ENG-SP20003-R5-PDR.pdf Markup Summary

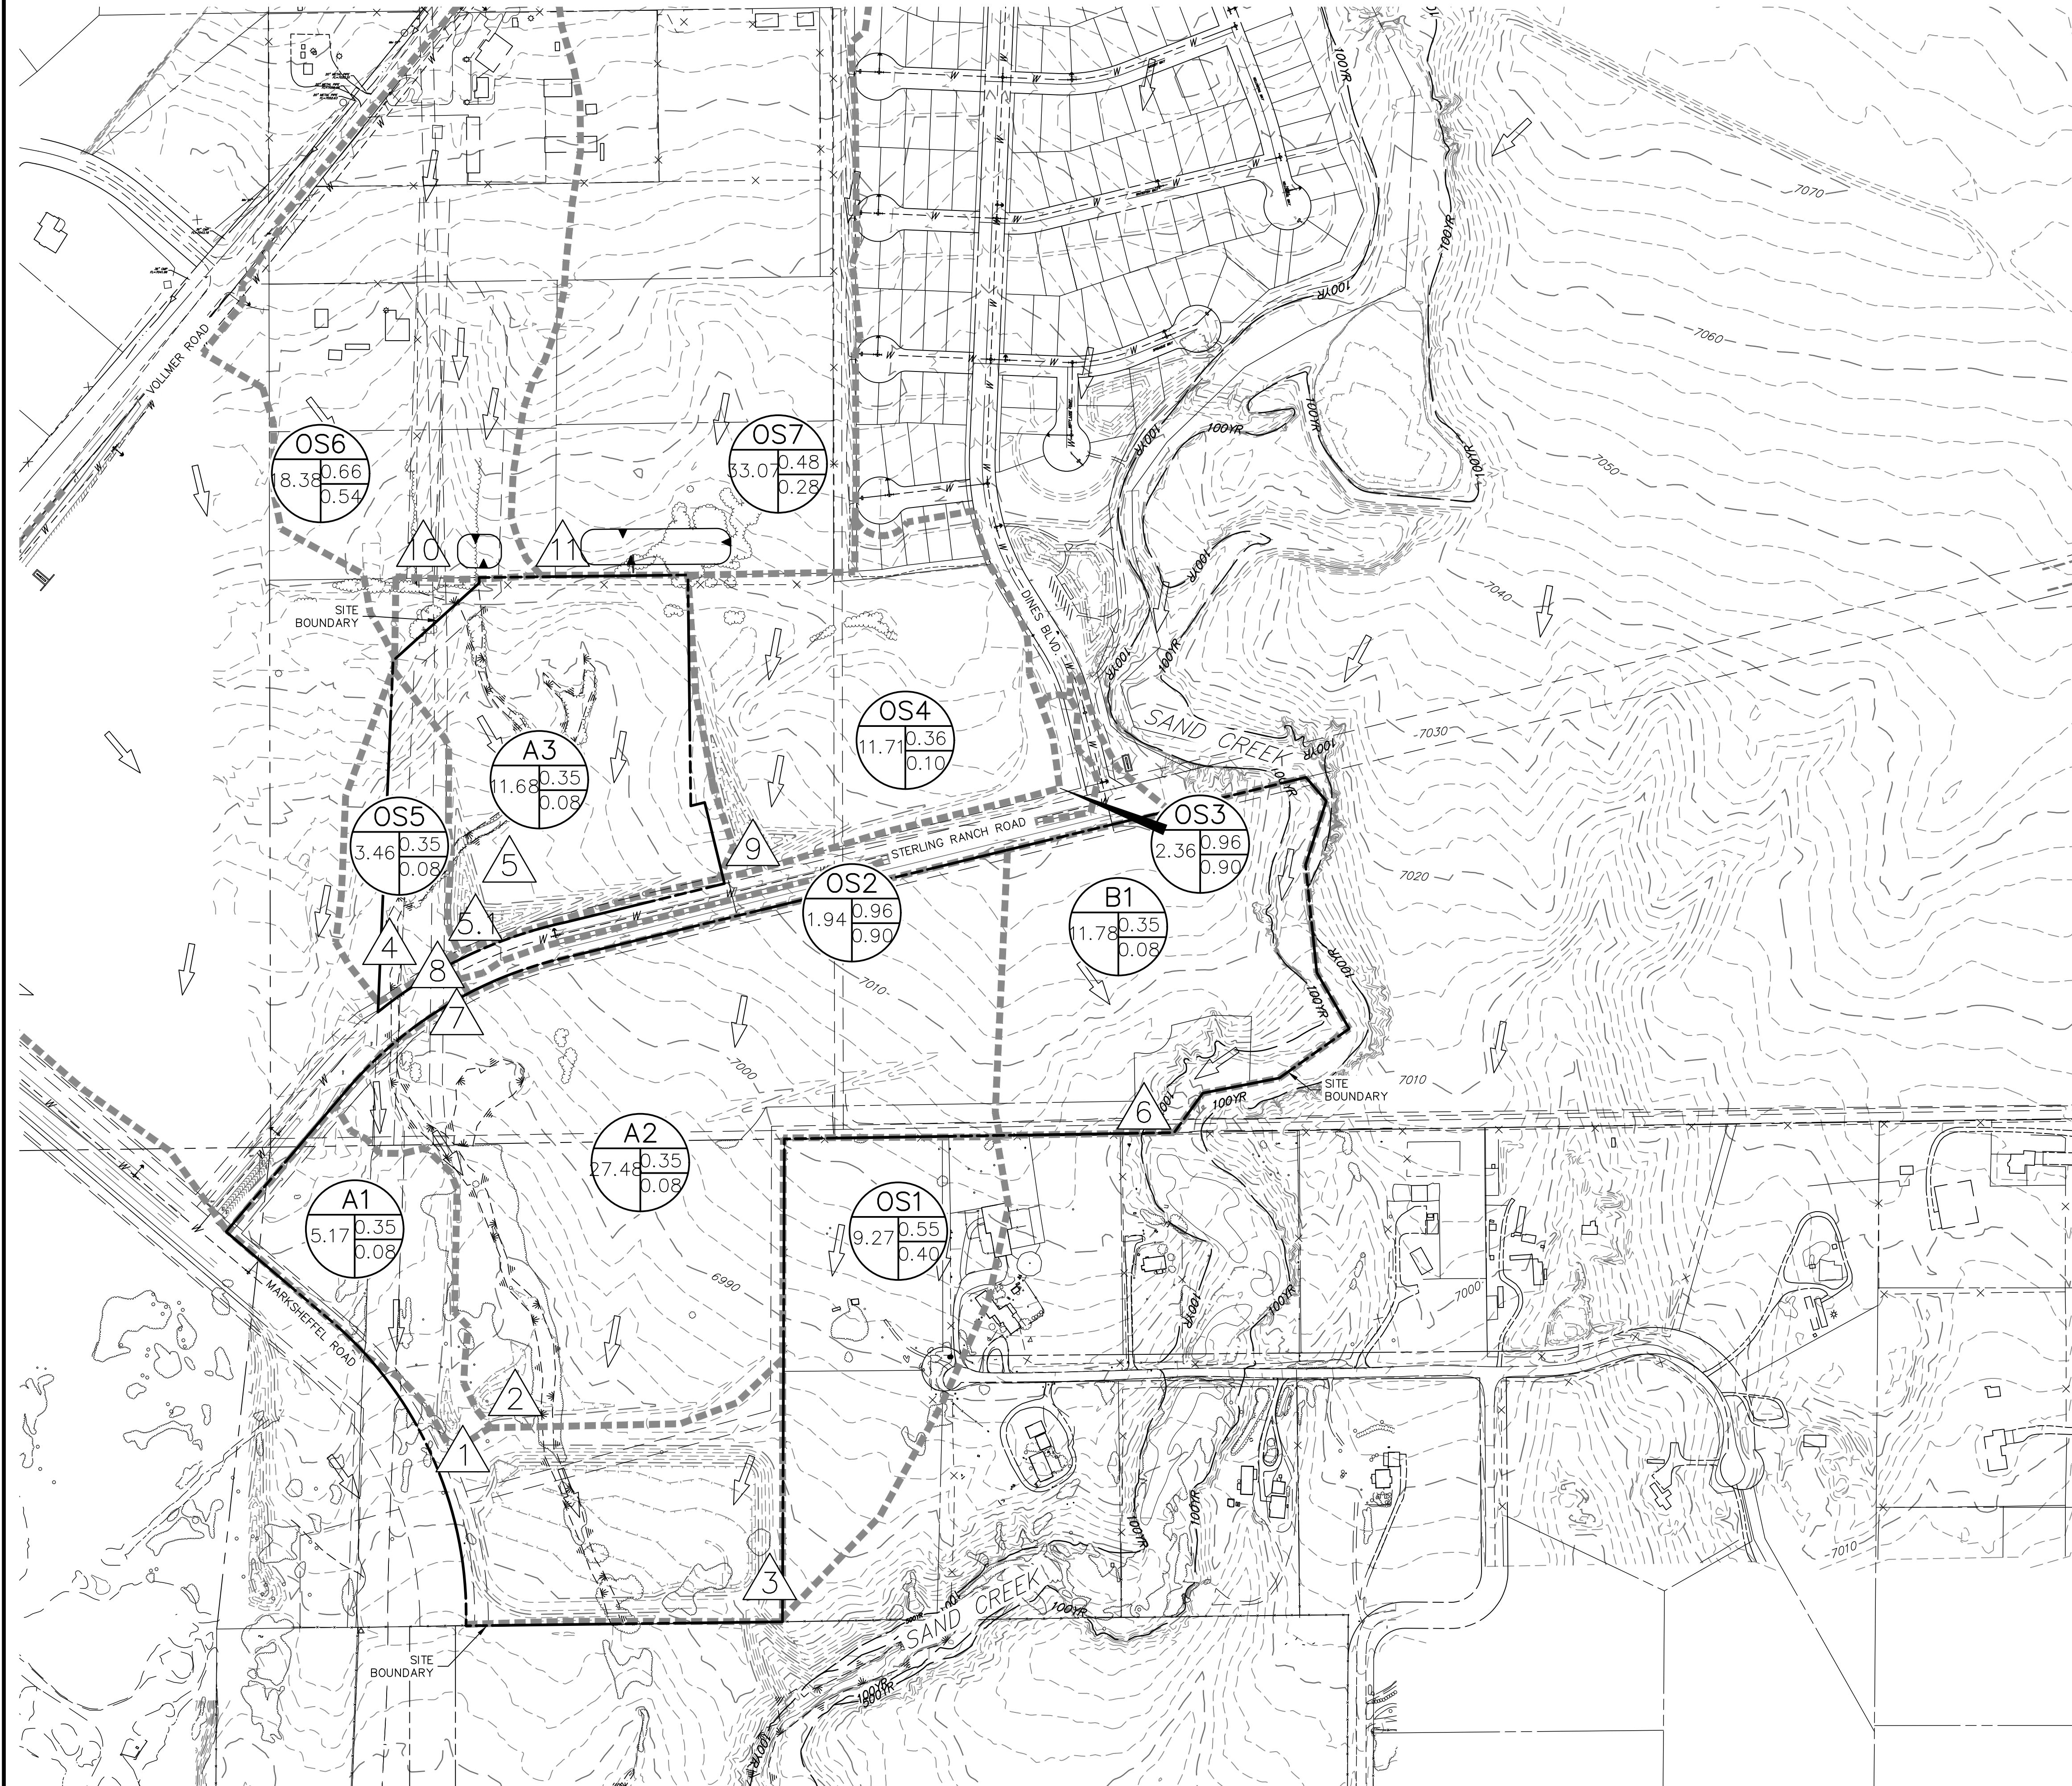
use latest plan

STERLING RANCH PHASE 2 PROPOSED DRAINAGE MAP

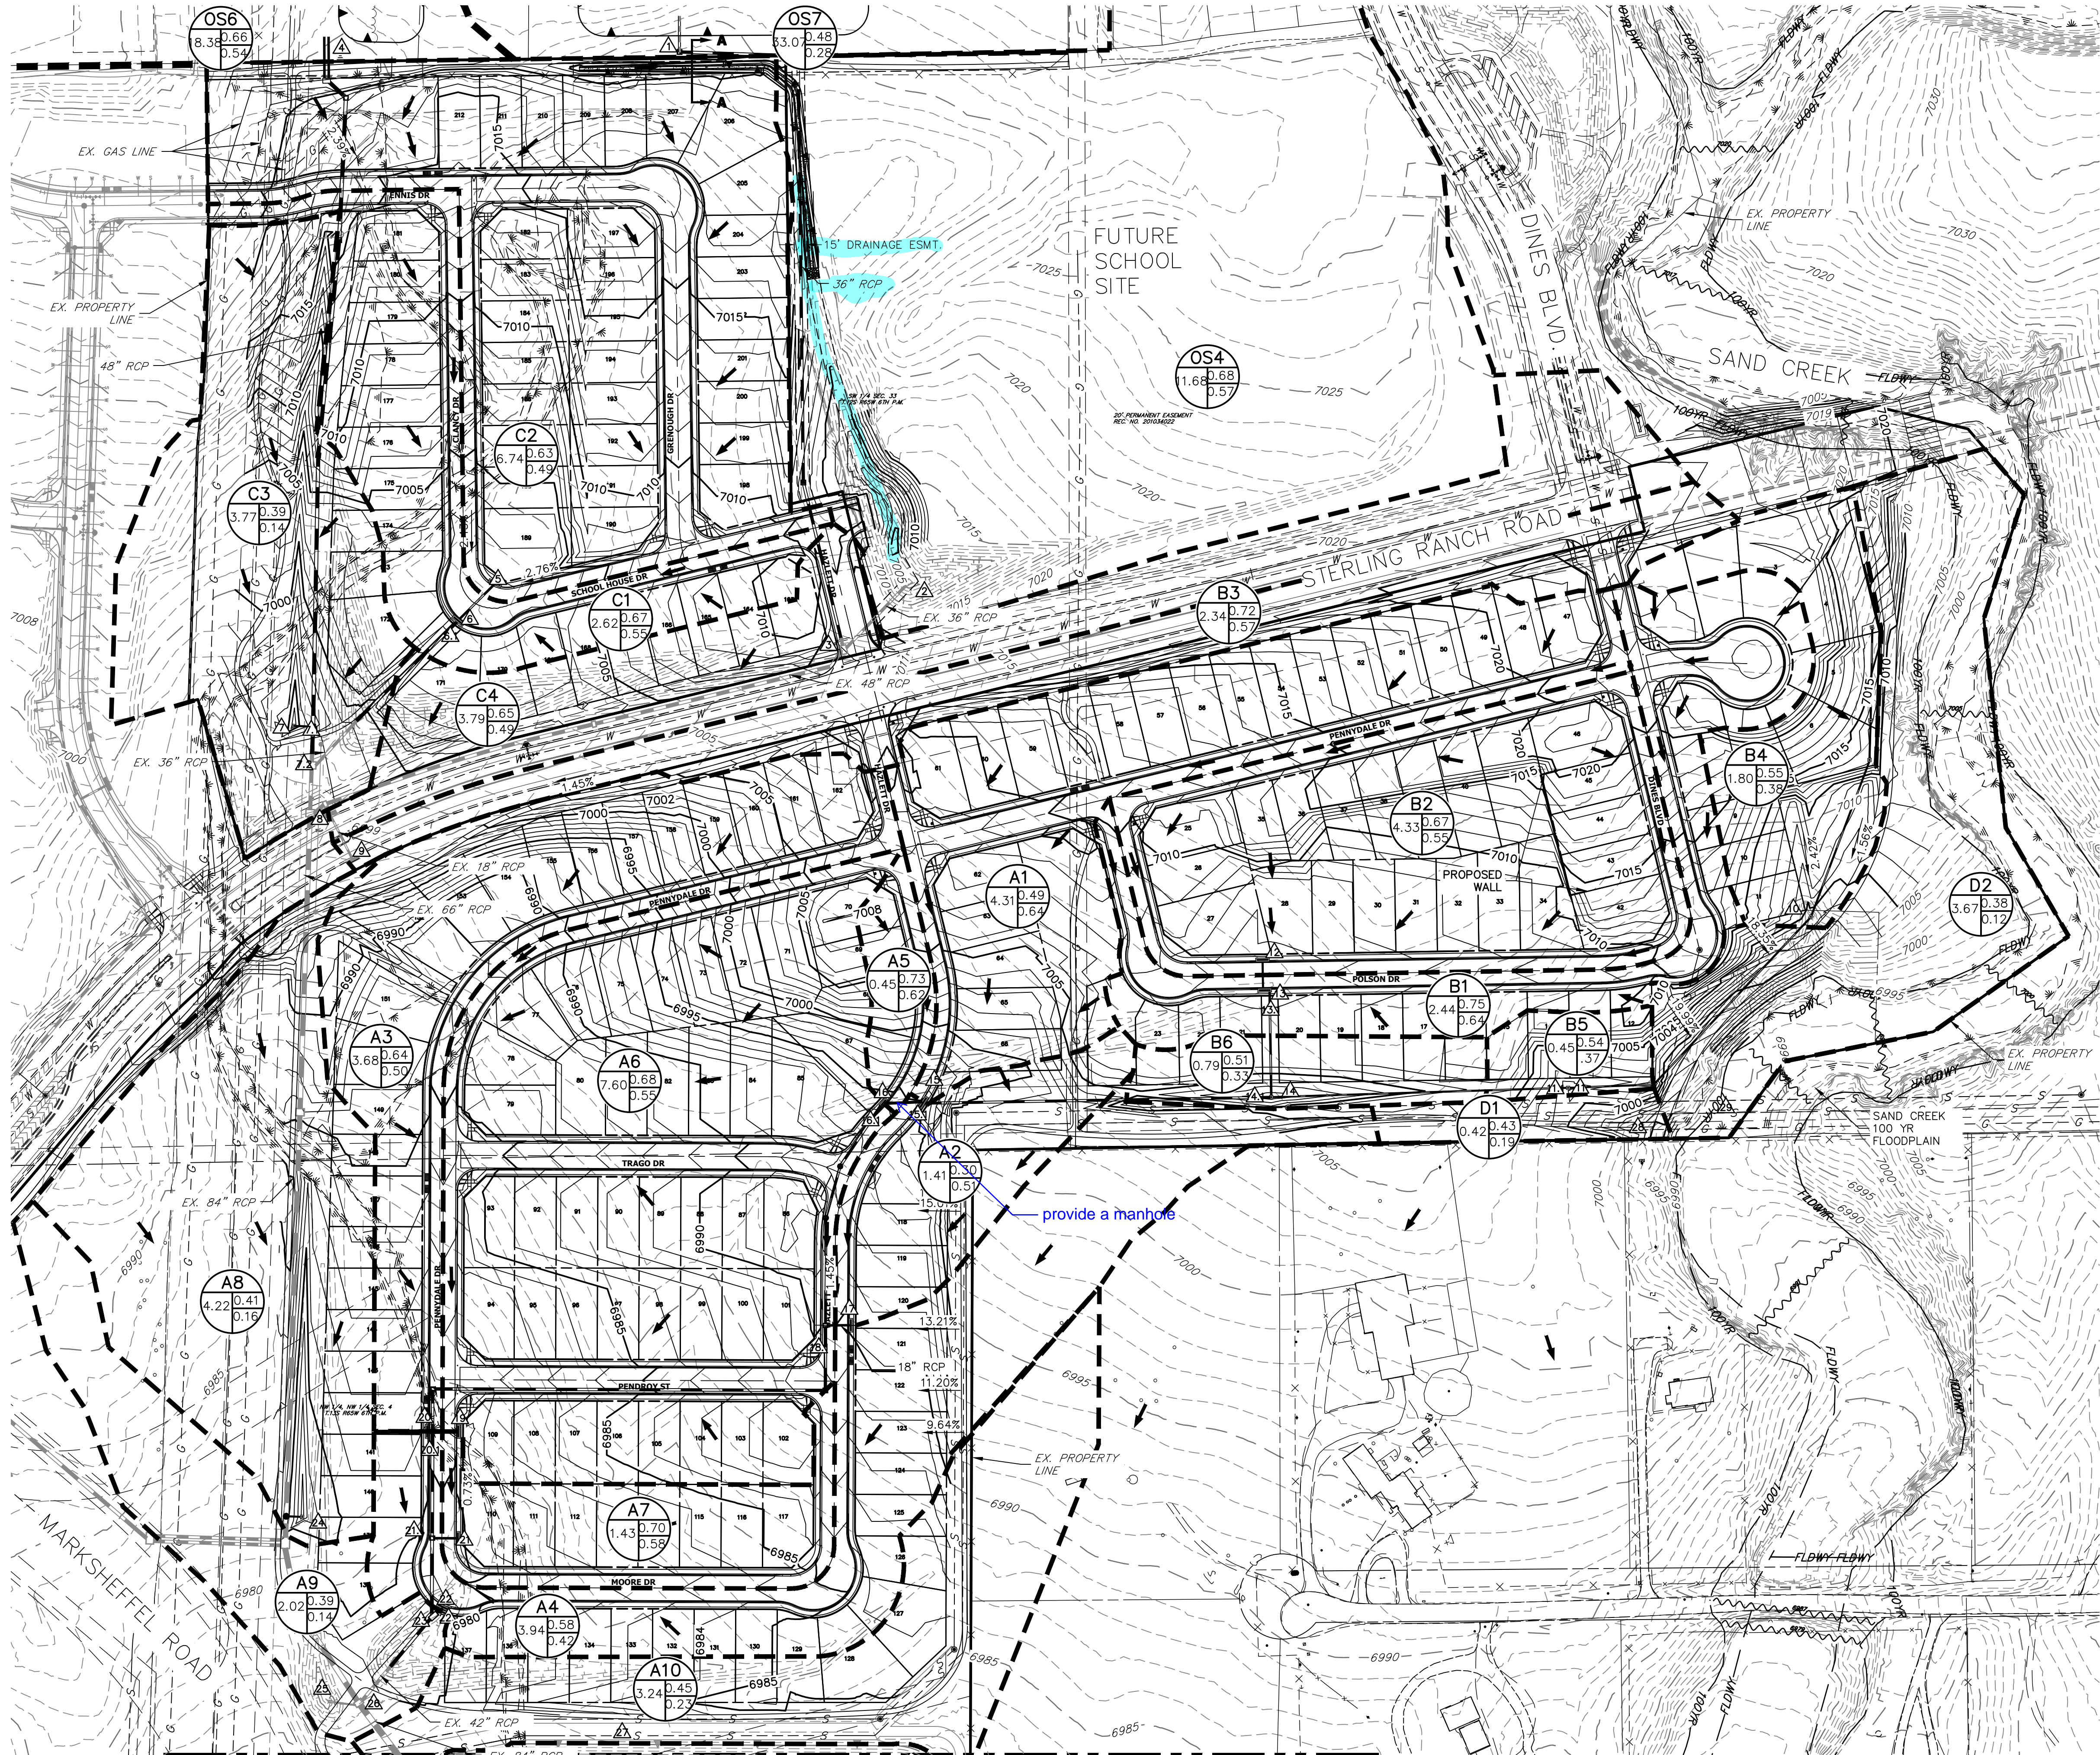
provide a manhole

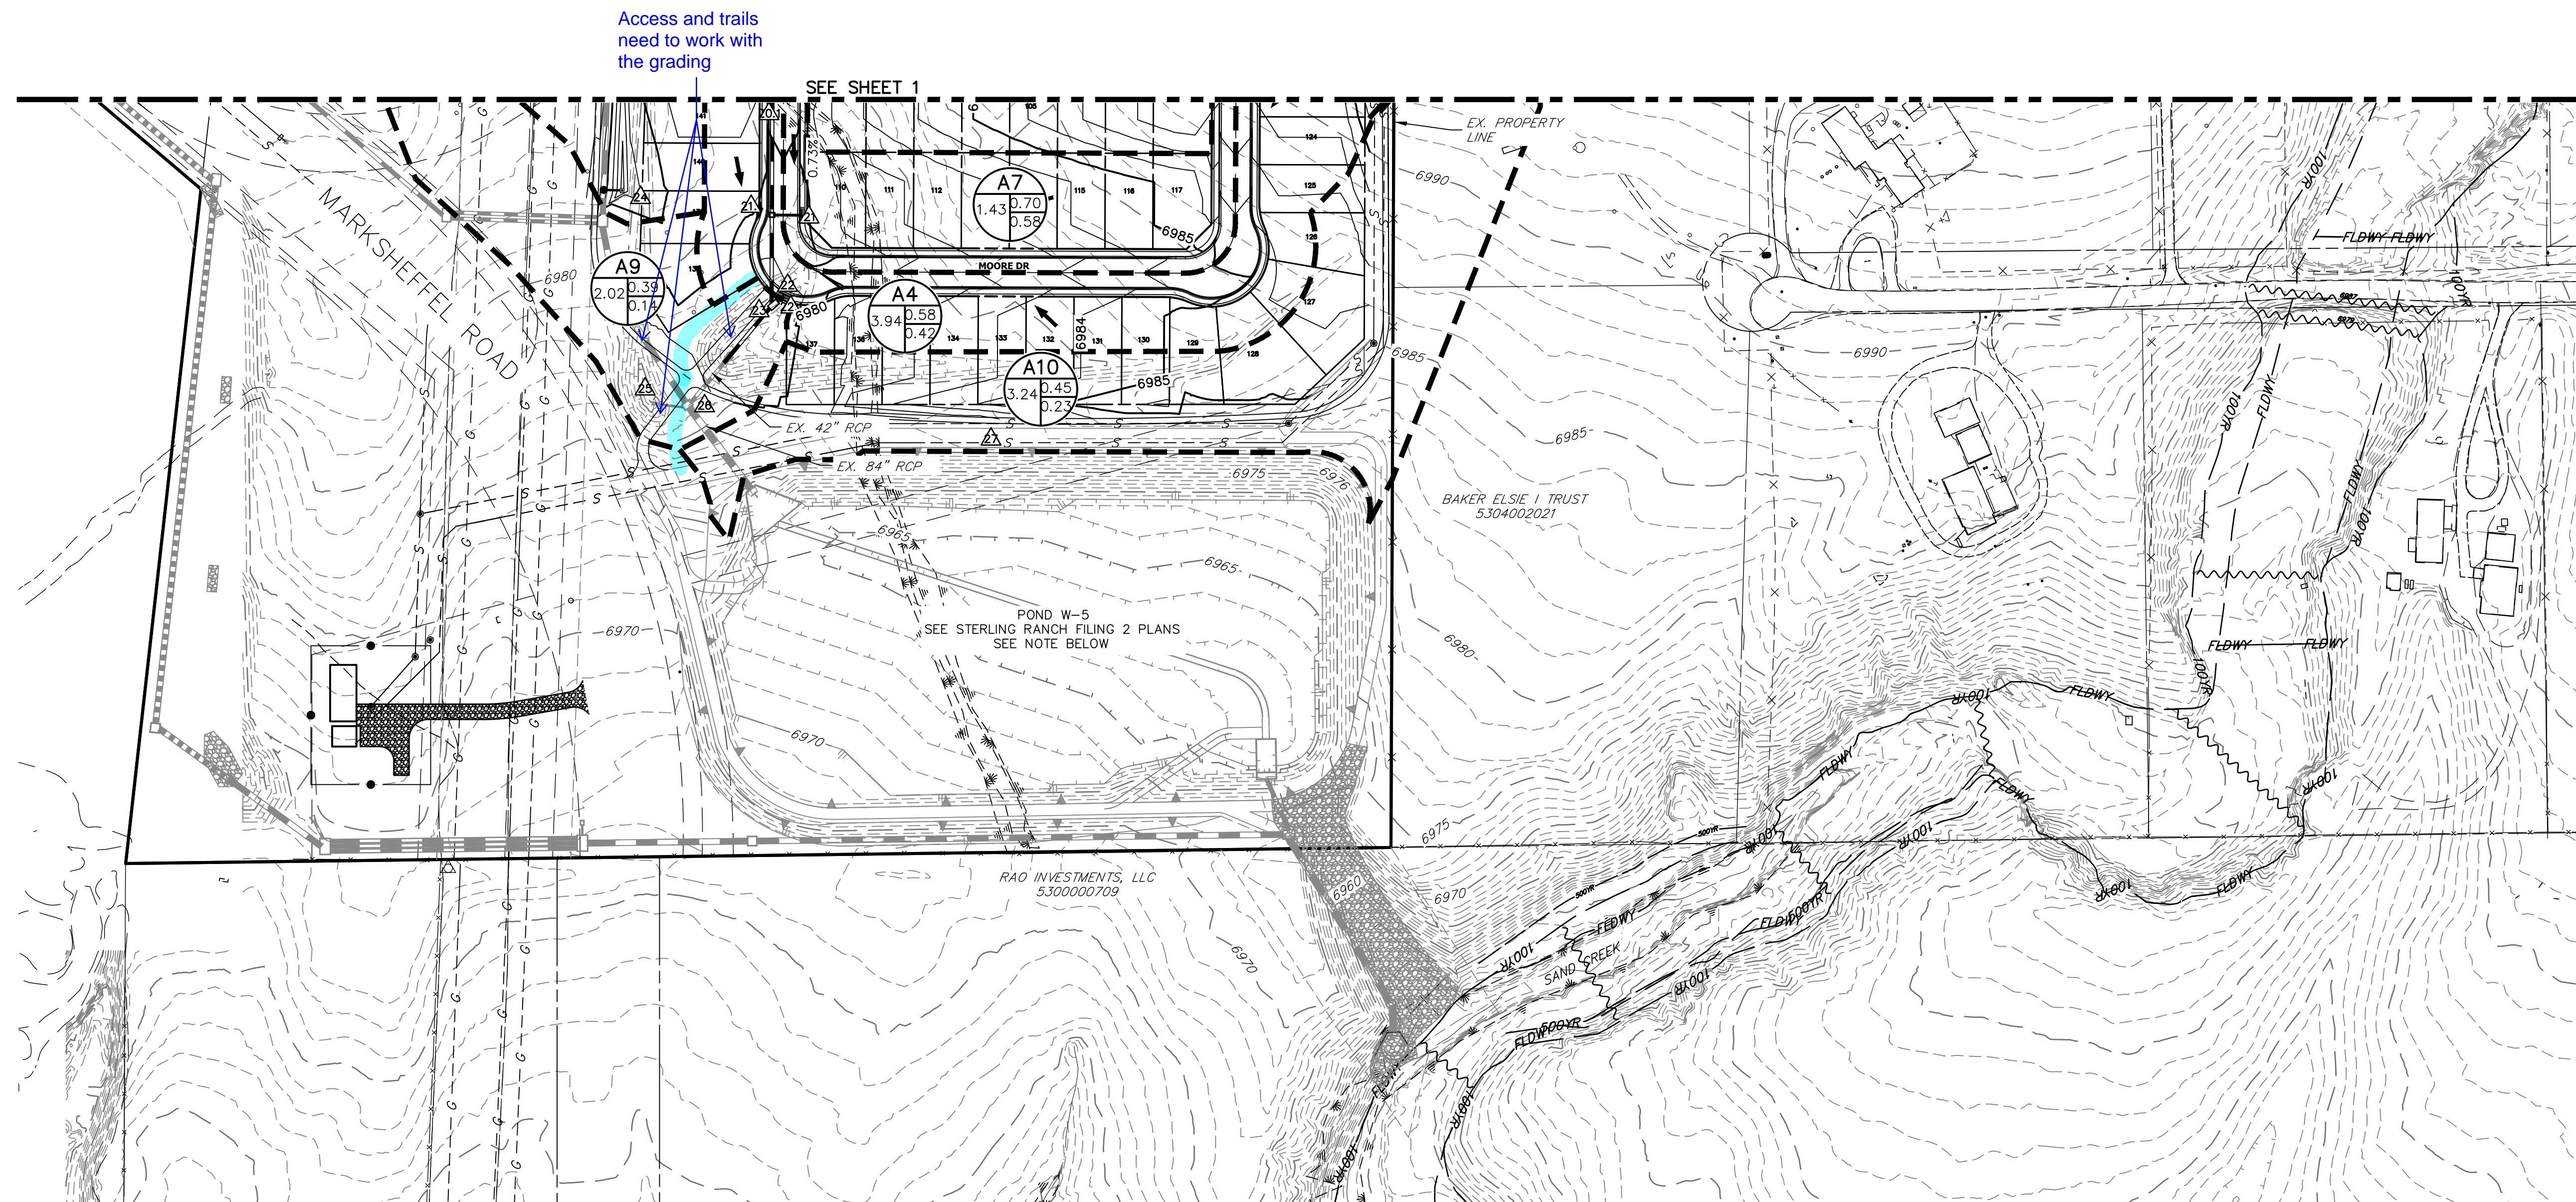
Access and trails need to work with the grading
